EROSION AND STORMWATER QUALITY CONTROL PERMIT (ESQCP) EL PASO COUNTY APPLICATION AND PERMIT

CEG #315.002

Project Specifications	
Project Name	Equipment Resources, 7340 Utah Lane
Legal Description	Section 8, T15S, R65W
Address (or nearest major cross streets)	Utah Lane & Adventure Way located southeast of Woodmen Road/Black Forest Rd.
Acreage (total and disturbed)	Total: 5 acres Disturbed: 0.1 acres (on-site)
Schedule	Start of Construction: August, 2019 Completion of Construction: December, 2019 Final Stabilization: December, 2019
Project Purpose	Construction of PLD's so condition use permit doesn't have to be renewed each year.
Description of Project	Construction of two PLD's and 8" storm sewer for water quality requirements
Tax Schedule Number	5308000007

FINAL DRAINAGE PLAN
7340 UTAH LANE
EL PASO COUNTY, COLORADO

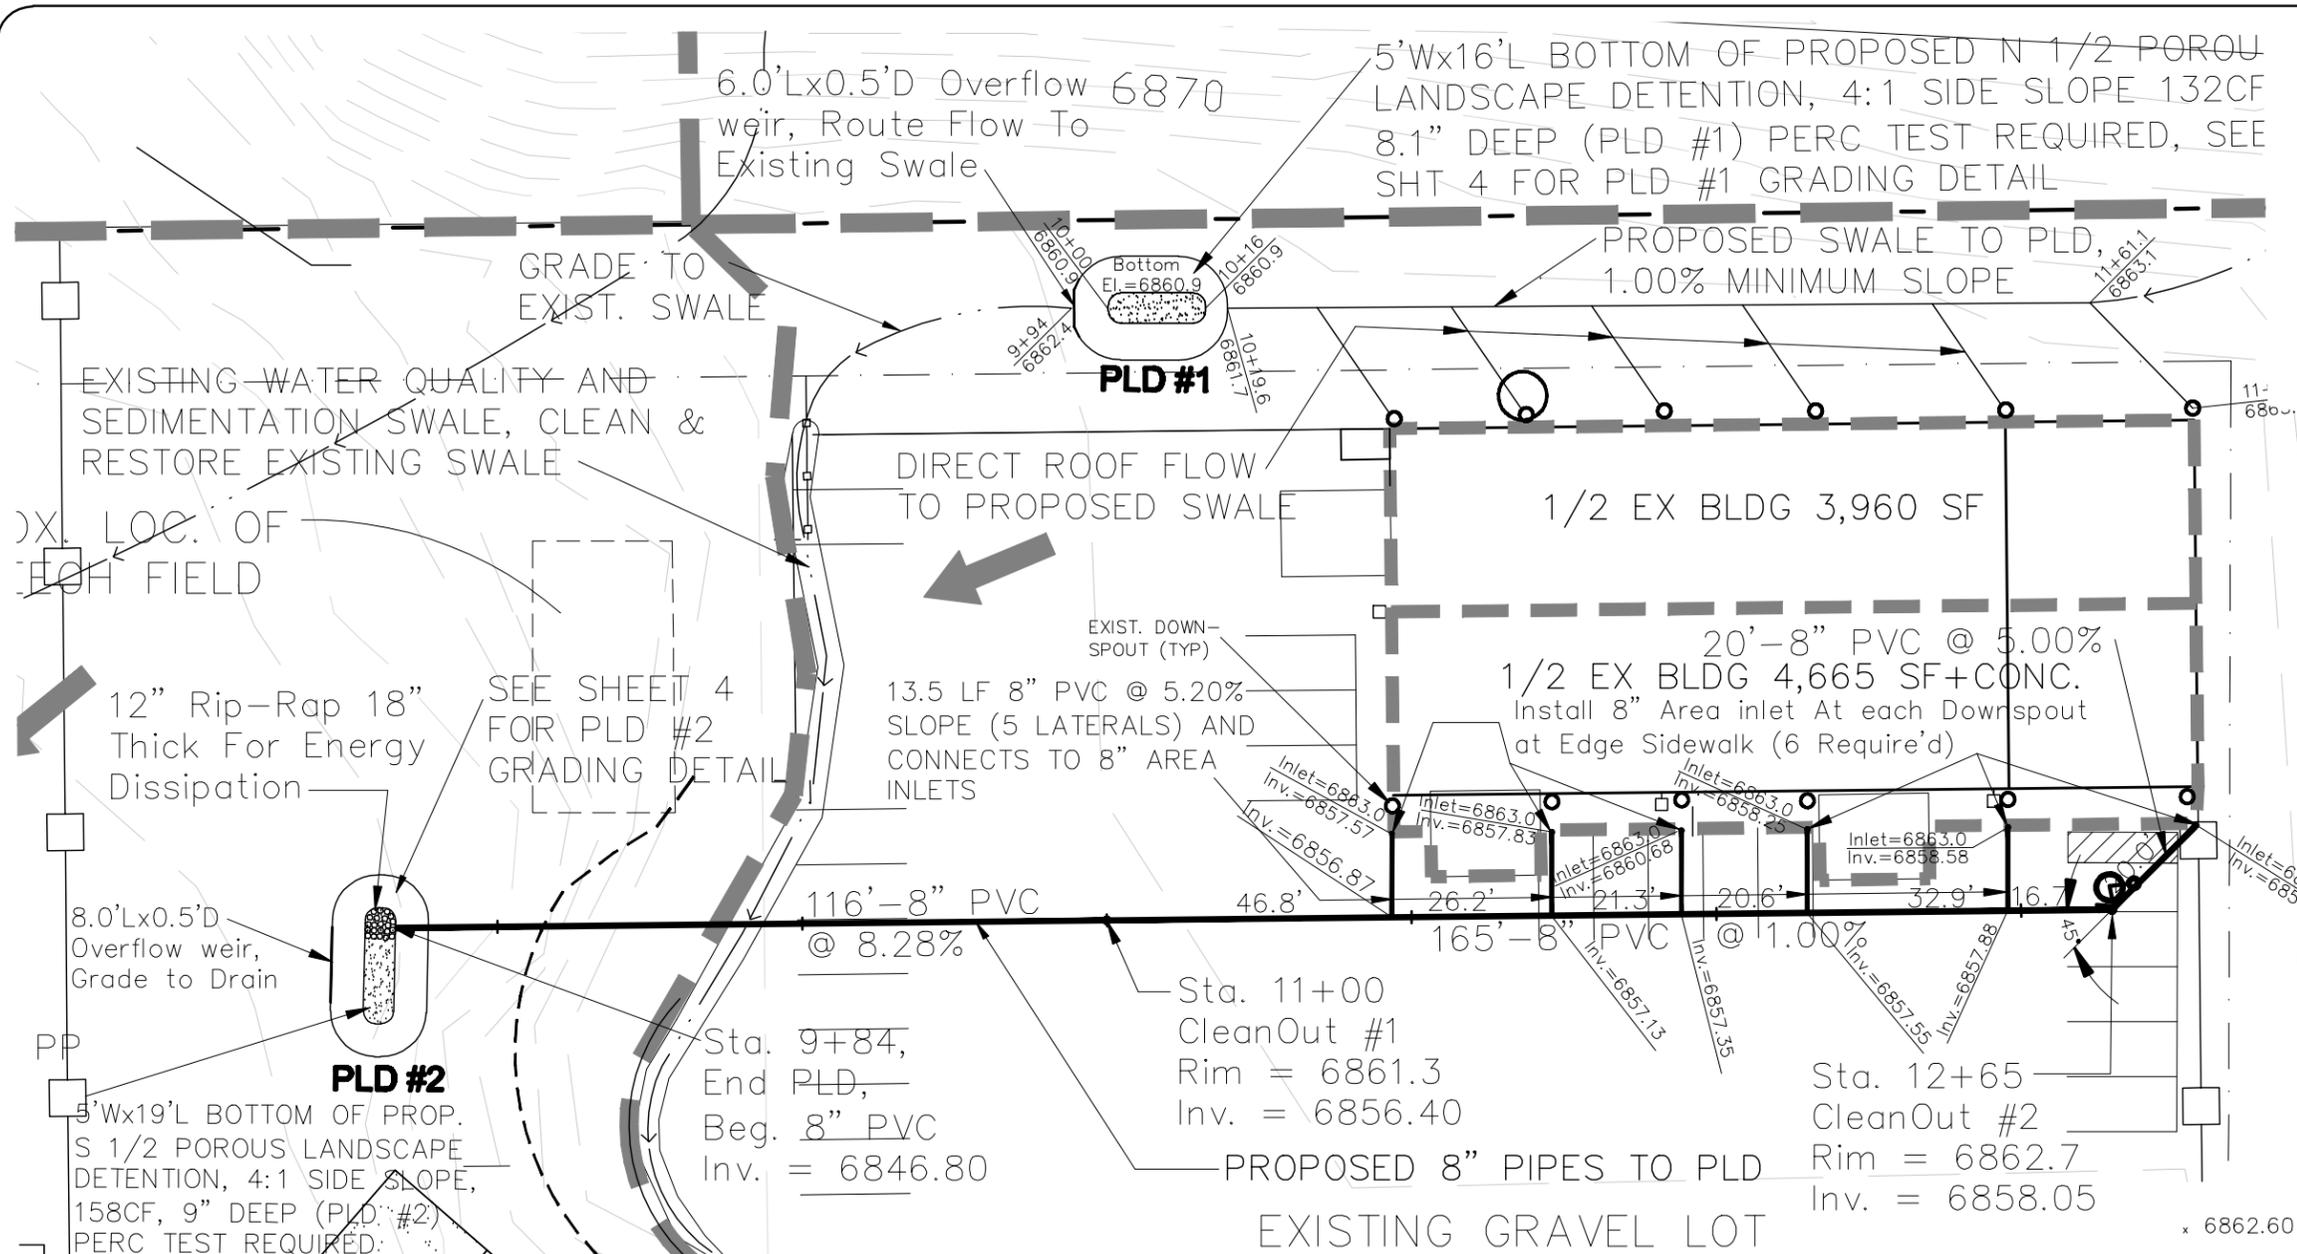
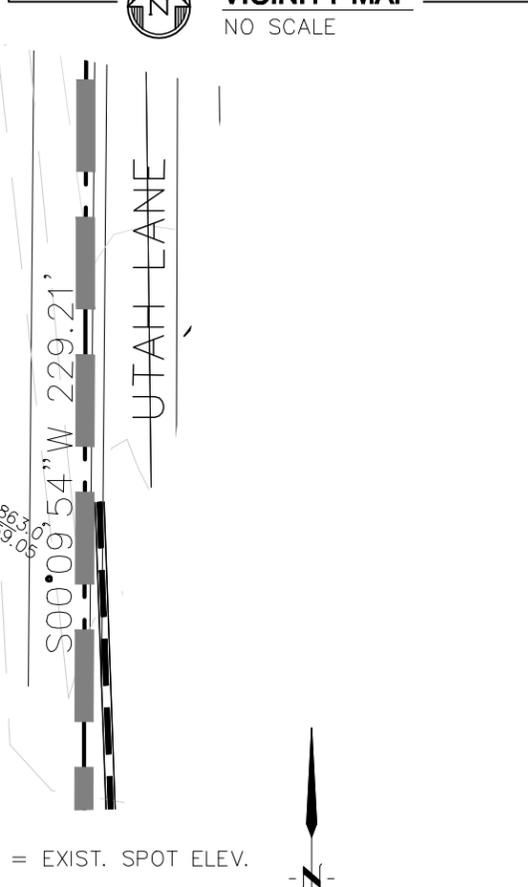
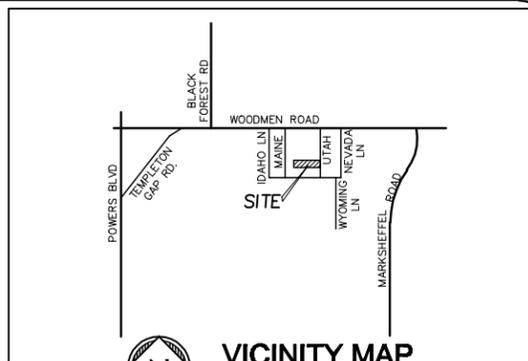
In the site plan it also appears that the western portion of the property is going to be used as storage and a gravel drive is being placed. Include the installation of the gravel drive and storage area.
